**WEST SUSSEX COUNTY COUNCIL
STRATEGIC PLANNING CONSULTATION**

SUBJECT: A/11/17/OUT

Hybrid Application to include Full planning permission for a retail unit (Class A1) comprising 1,487sqm with associated access, car parking, servicing, landscaping & associated works & Outline planning permission with some matters reserved (scale & appearance) for public house (Class A4) comprising 581sqm (resubmission following A/23/15/OUT).

Land south of, New Road (A259) & East of Brook, Angmering

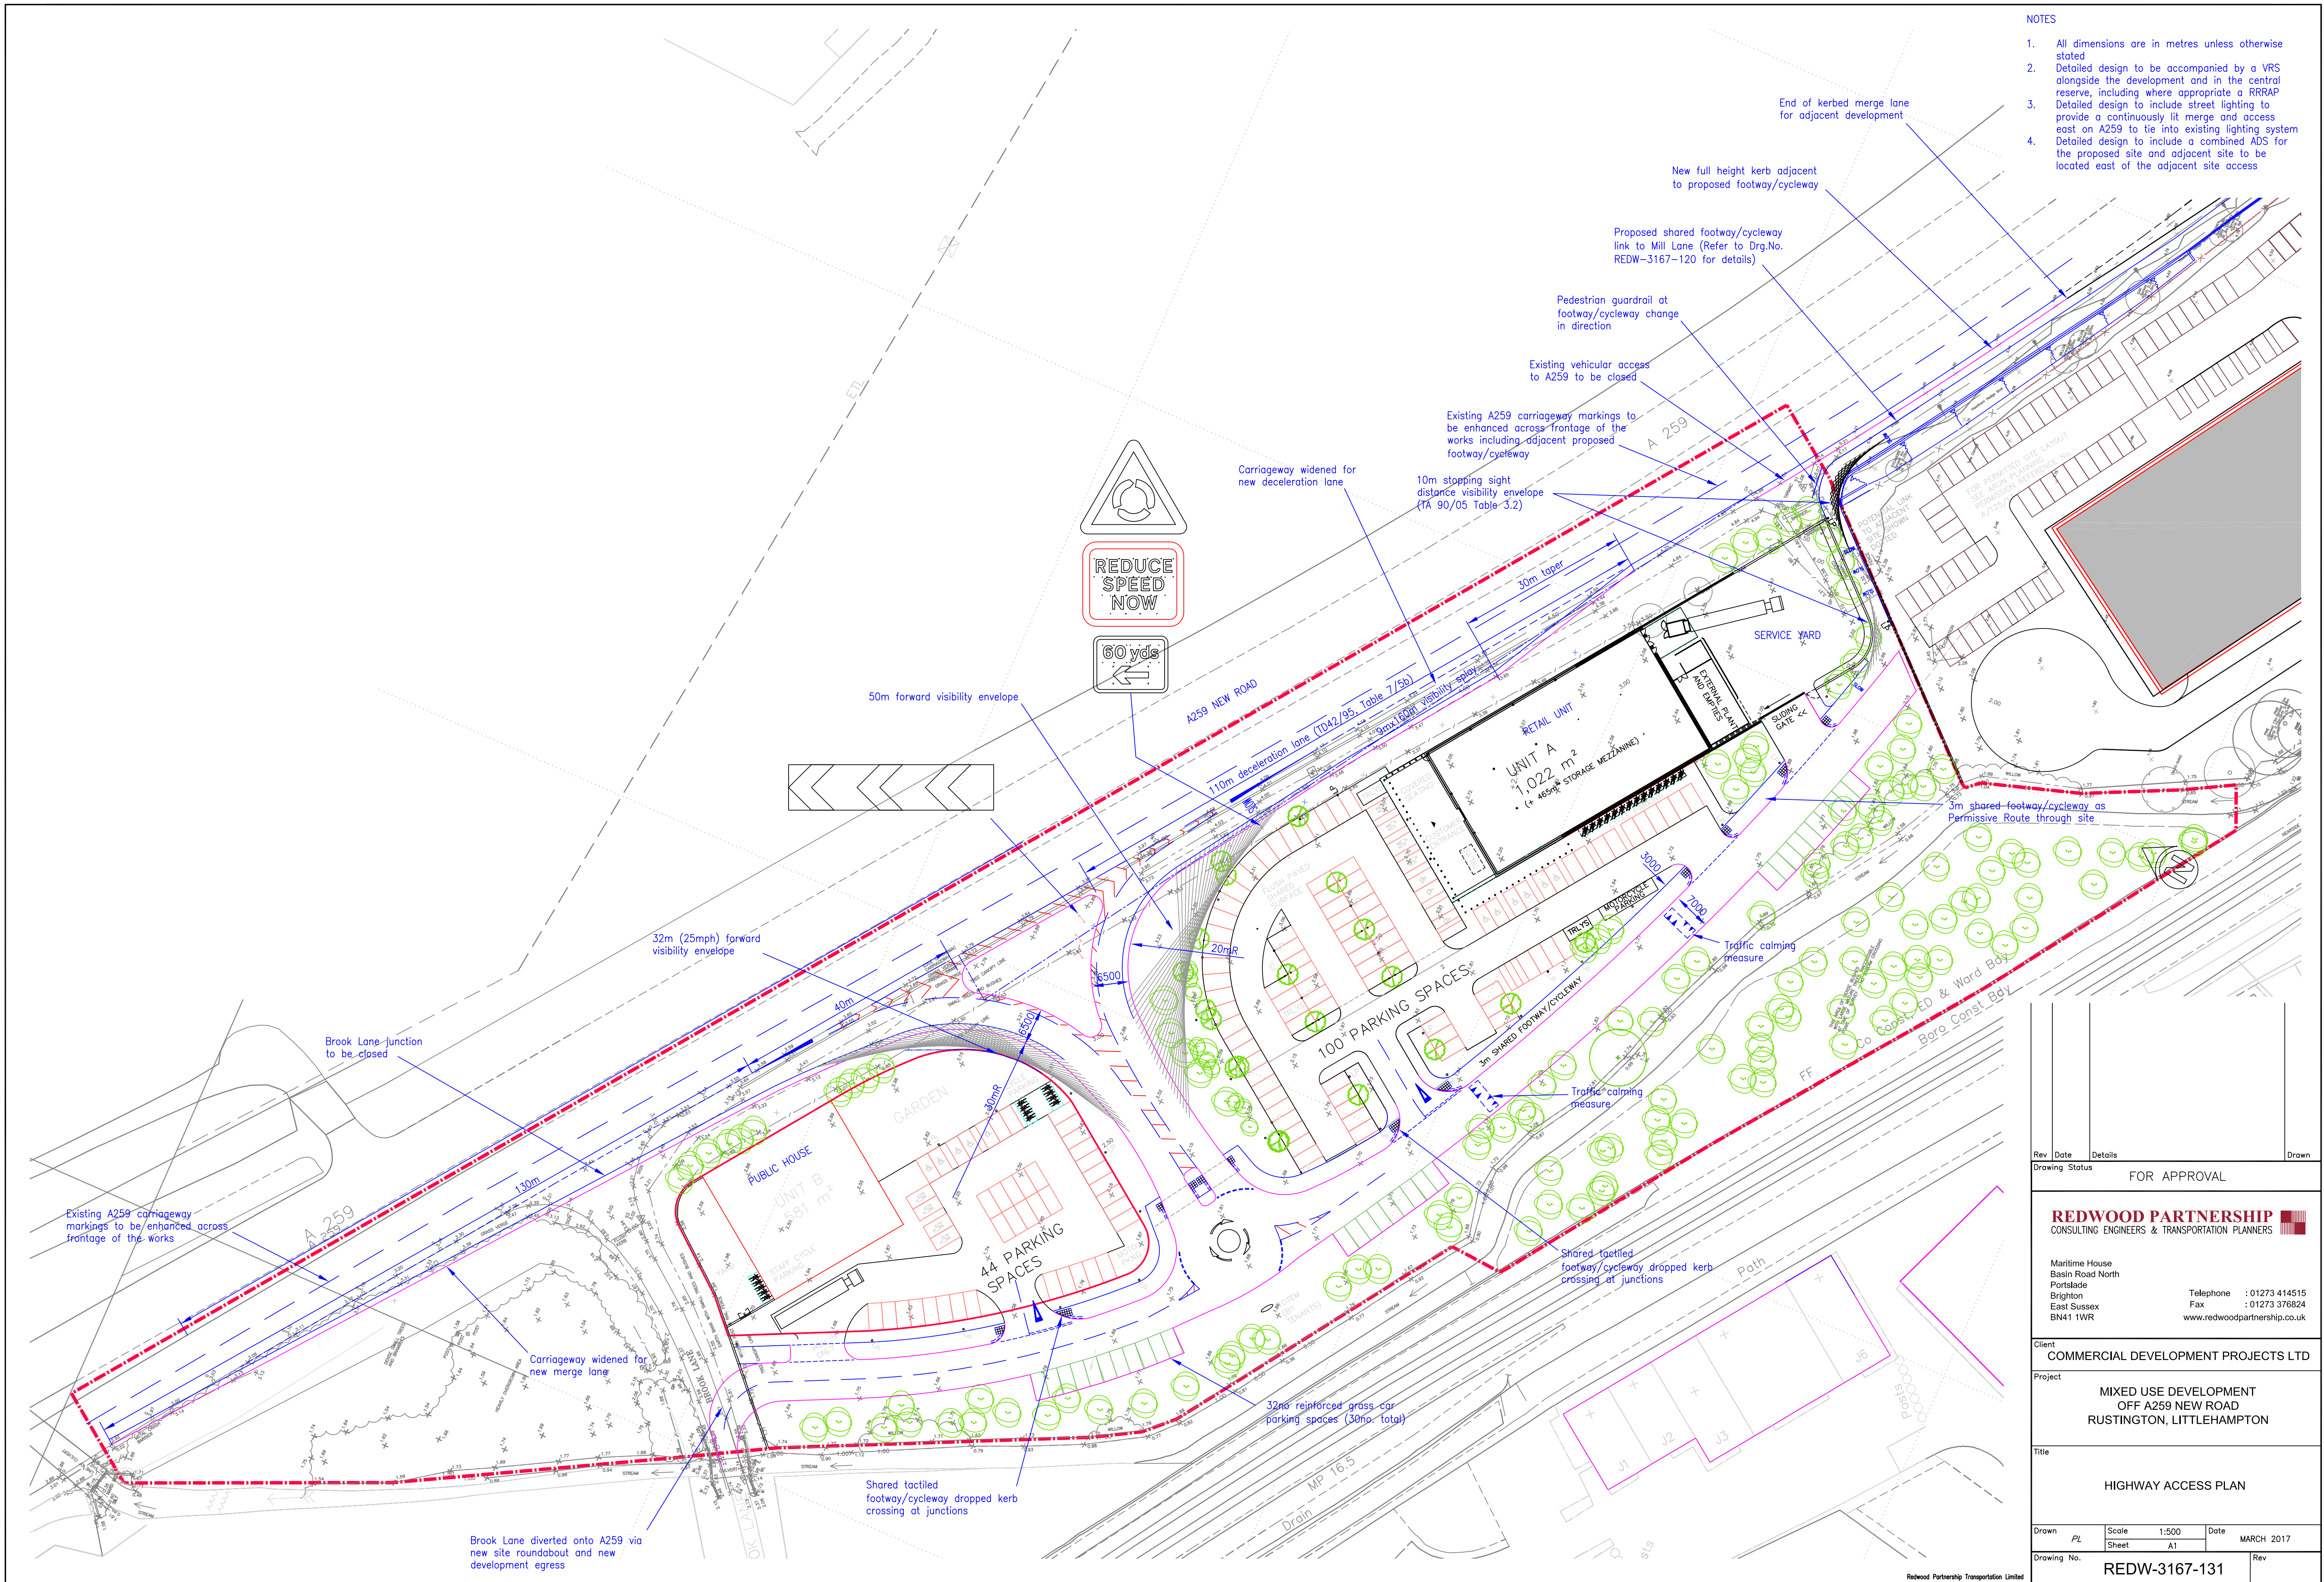
Tactile paving at cycle route crossings is not in accordance with guidance, and this matter should be resolved as part of any detailed design.

The 20m radius and the implications of the previous departure has been reviewed and found to be acceptable. It is accepted that the deceleration lane is of sufficient length to bring a vehicle to a halt at a give-way line.

It will be necessary to review the orientation of hatching on eastern arm of mini roundabout at the detailed design stage.

Set back cycle route crossing point by mini roundabout 5m from stop line, i.e behind first waiting car.
